Our Ref: BR/106/17/HH

**Town & Country Planning Act 1990 (as amended)
Town & country Planning (Development Management Procedure) (England) Order 2015
Application for Householder Planning Permission**

Development Rear extension
Location 125 Orchard Way Bognor Regis

SITE LOCATION & BLOCK PLANS			
Scale	1:1250 - 1:500	Drawn By	ACB
Date	01/11/2016	Checked	CB
Drawing Number	1360 - 01A

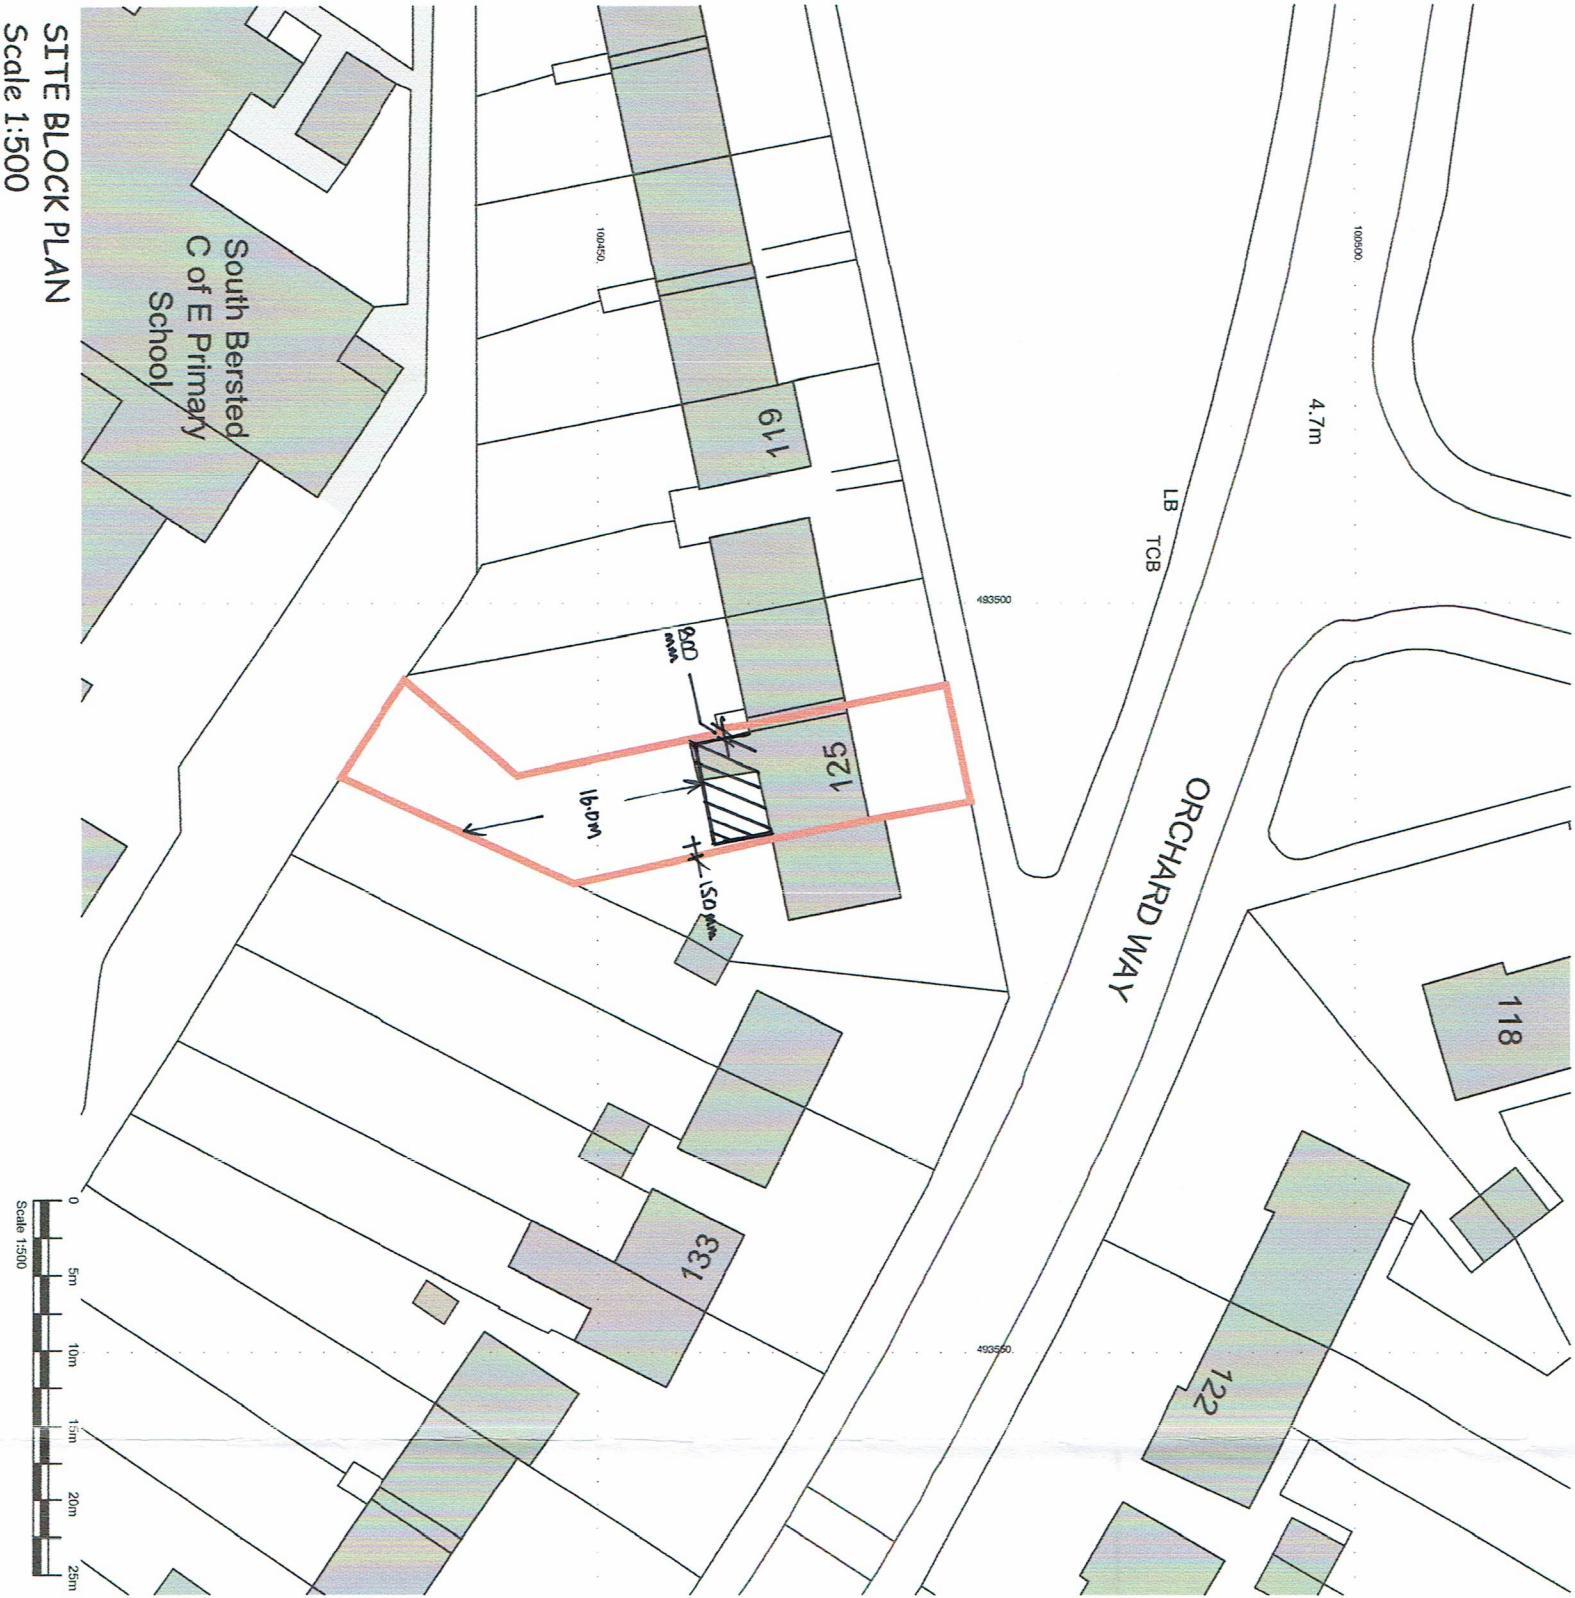
Block Plan Amend

Please submit 1 electronic or 3 paper copies of a block/site plan at a scale of 1:500 or 1:200. Further details of what must be included on the plan can be found in the National Validation Requirements. Please highlight/hatch the proposed works and provide measurements from the proposal to the site boundaries.
